**COMMENT RESOLUTION FORM**

<b>Date:</b>	1/27/2022	<b>Disposition Codes:</b>	
<b>FHU Project Number</b>	117253-08 EPC Reviews 2022	<b>A. Accept Comment</b>	<b>E. Comment Conflicts with Previous Direction</b>
<b>Project Name:</b>	Briargate Blvd over Sand Creek Bridge	<b>B. Delete Comment</b>	<b>F. Designer to Evaluate Comment</b>
<b>Project Number:</b>	EPC PCD CDR2113	<b>C. Clarify Comment</b>	<b>G. Discuss Comment; Follow-up Required</b>
<b>Client:</b>	El Paso County	<b>D. Disagree with Comment</b>	
<b>Designer:</b>	Kiowa Engineering Corporation		
<b>Submittal:</b>	1/03/2022 Plans; 12/6/2021 Sand Creek Drainageway Design Report; 1/29/2021 Subsurface Soil Investigation	<b>Other Review:</b>	N/A

C001

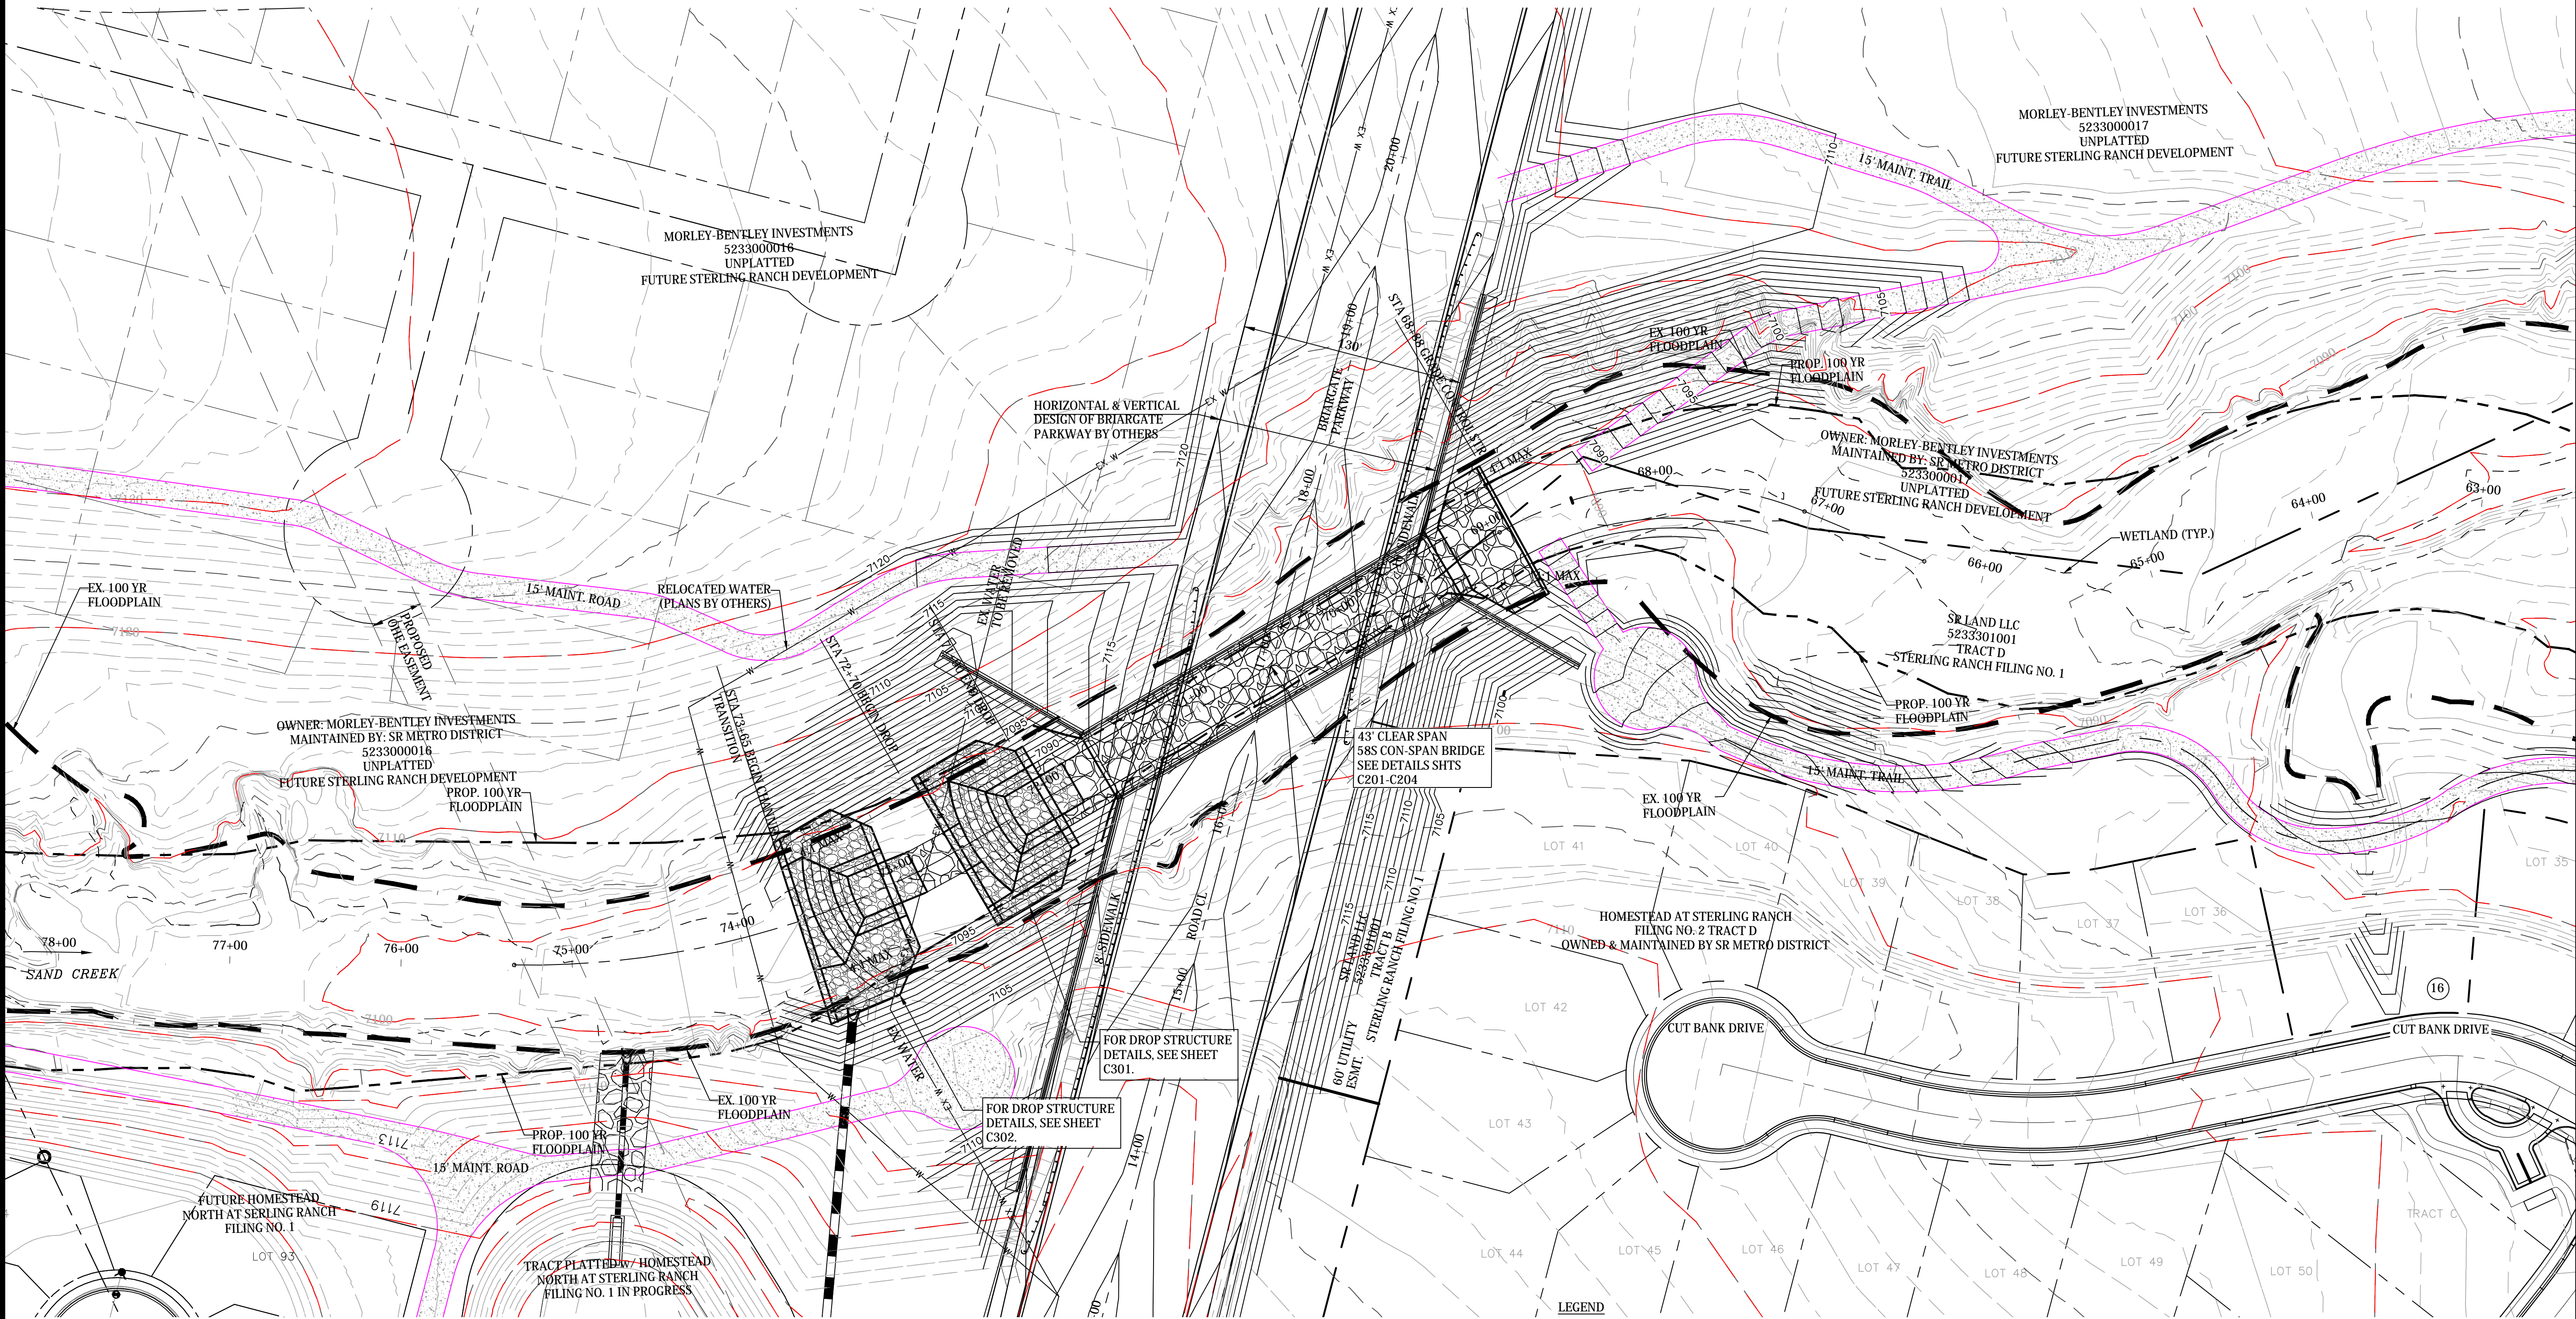
6	CAO	C001	State which year is applicable.						
7	CAO	C201	Suggest showing boring location in plan view for reference.						
8	CAO	C201	Does not correlate with thickness shown in Section B on Sheet C203.						
9	CAO	C201	Nothing submitted. Footing detail is show on C203. Is this not the intended detail?						
10	CAO	C201	Move grade control pile to the correction station in this view.						
11	CAO	C202	Label major contours.						
12	CAO	C202	Expand viewport to capture the end of this wingwall and TOC.						
13	CAO	C202	Sidewalk widths shown in this view do not appear to match plan view.						
14	CAO	C202	The bottom of this footing appears to be above the invert. What are bottom of footing elevations? Any required stepping for bottom of footing to align with grading?						
15	CAO	C203	Elevation does not match that shown on sheets C201 nor C202.						
16	CAO	C203	Section is cut at mid length of structure. Invert elevation should be less than 7089.00 per the bridge profile invert information. Otherwise this dimension seems off.
